KITTITAS COUNTY COMMUNITY DEVELOPMENT SERVICES

RE: VA-20-00010 Fuhr Variance

Mike Flory,
Building Official

EXHIBIT A

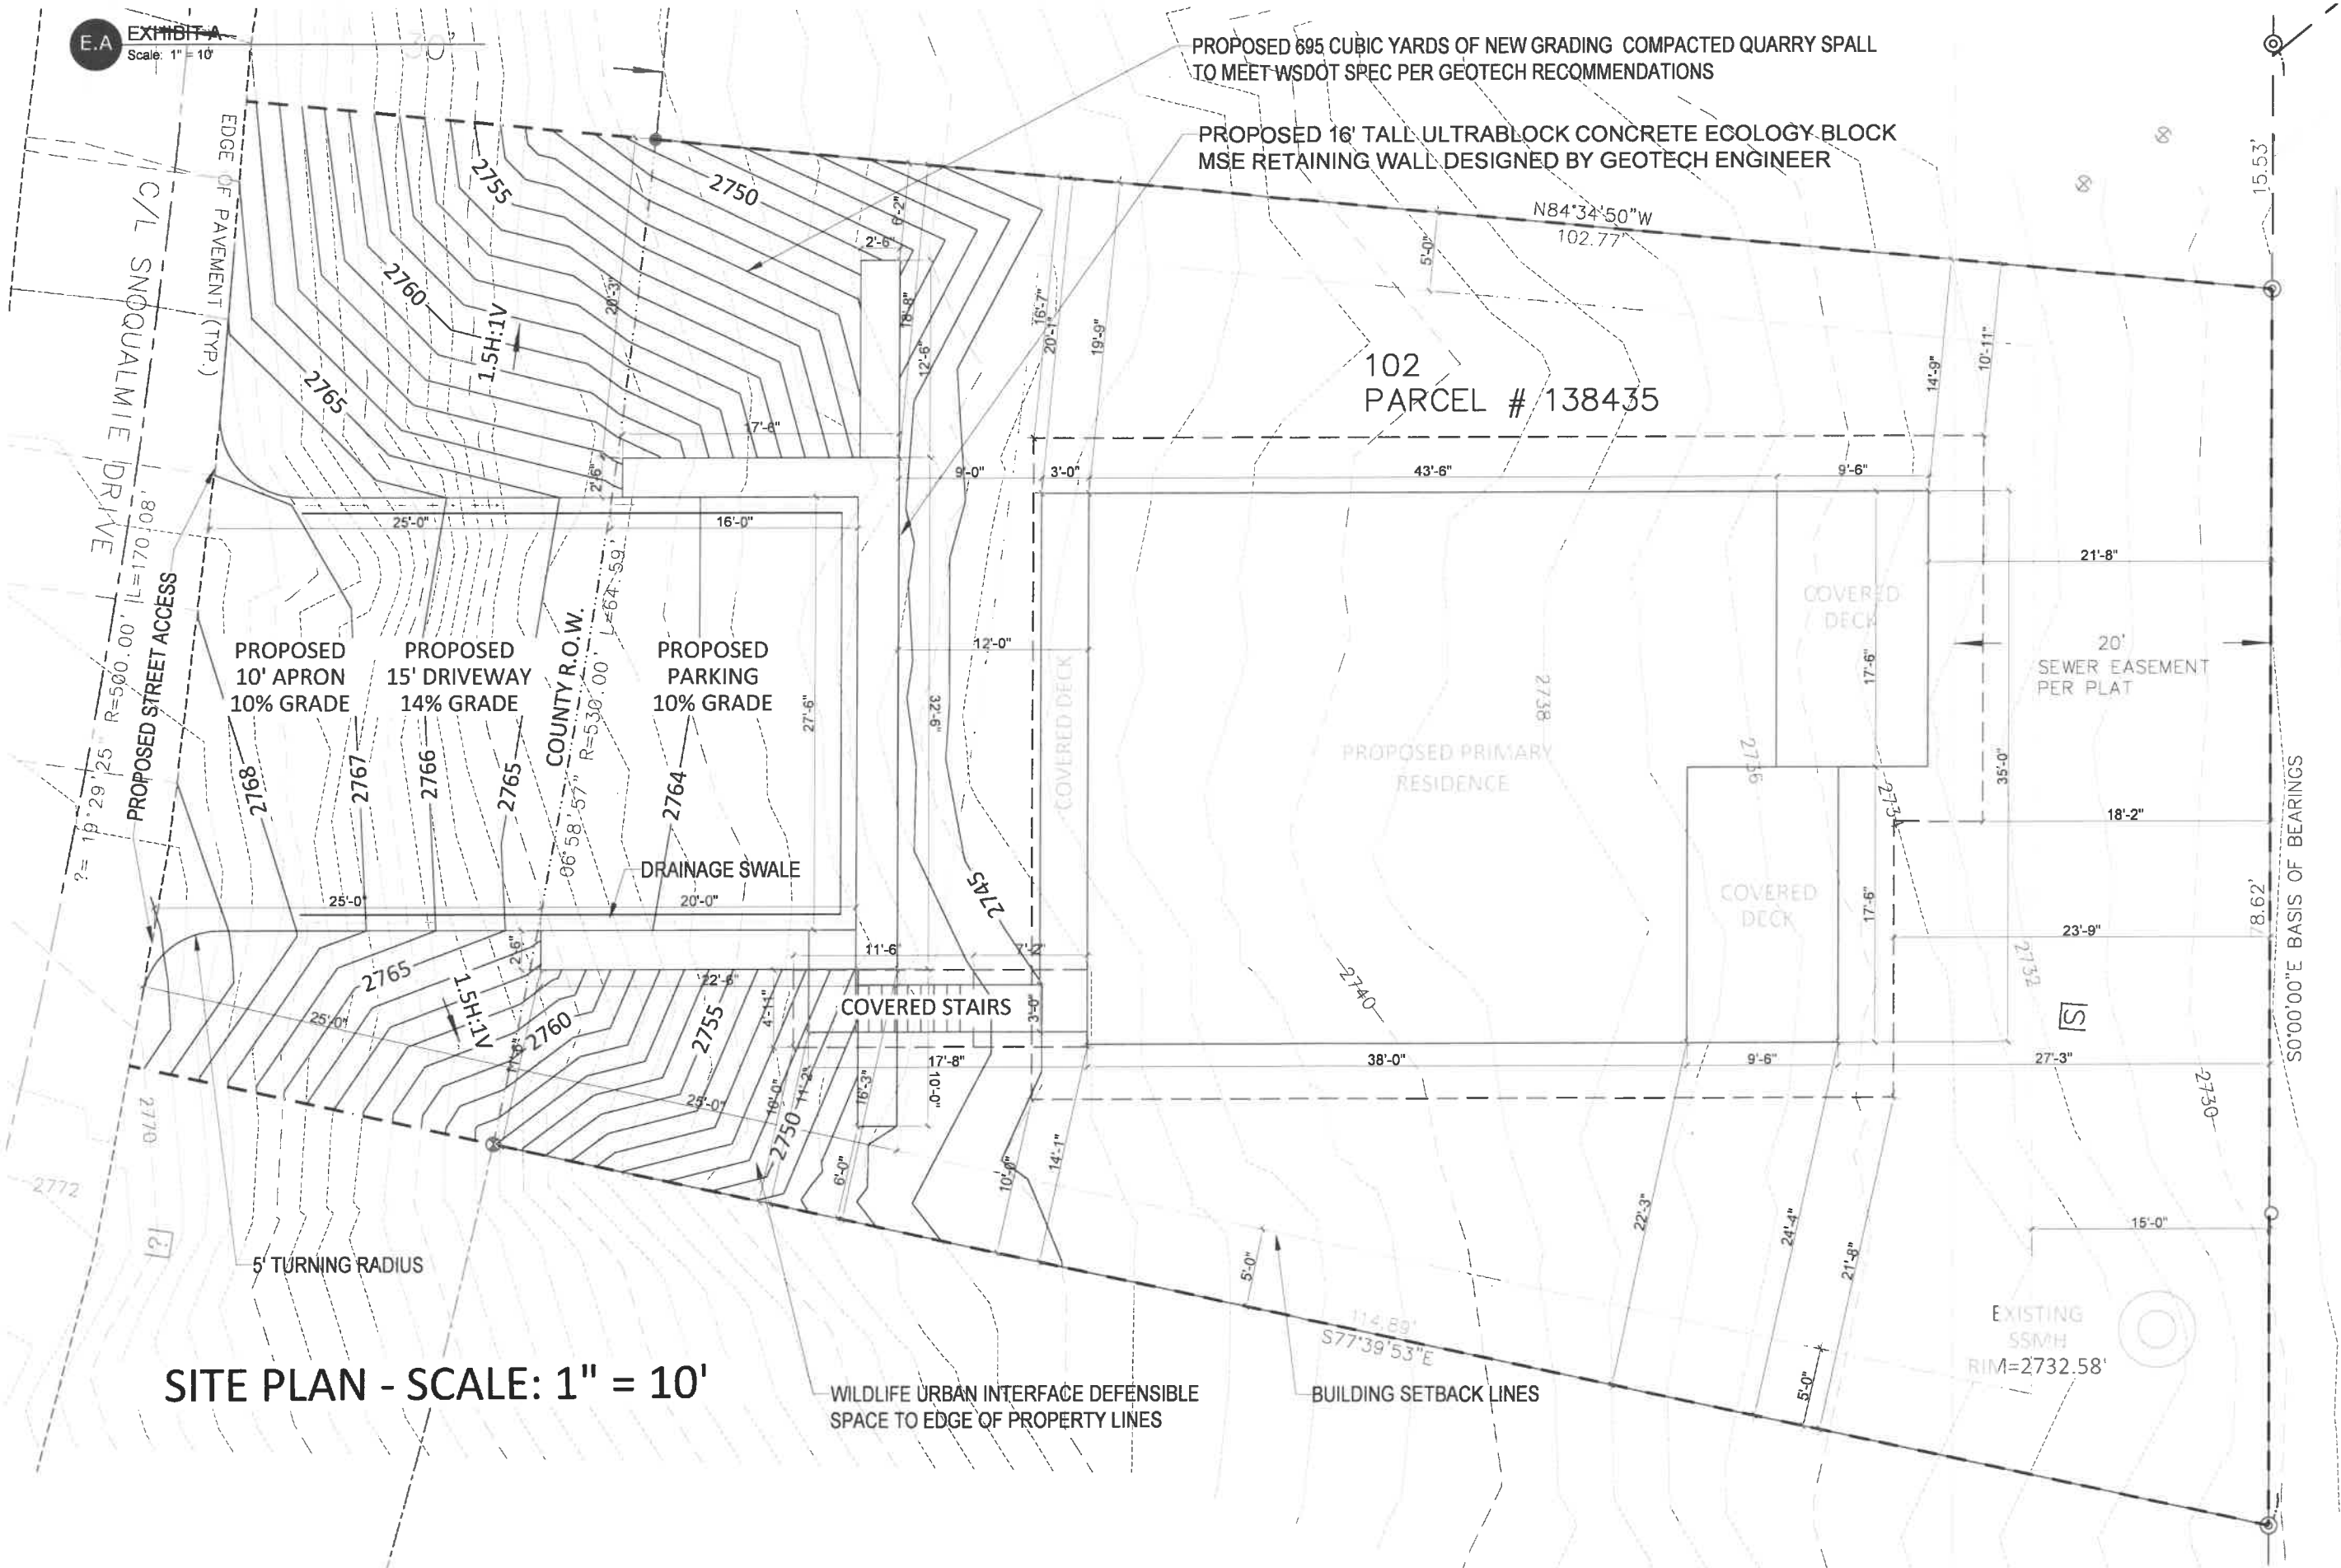
1. The CDS Building division has no opposition to the proposed variance and prefers the option of the shorter retaining wall.
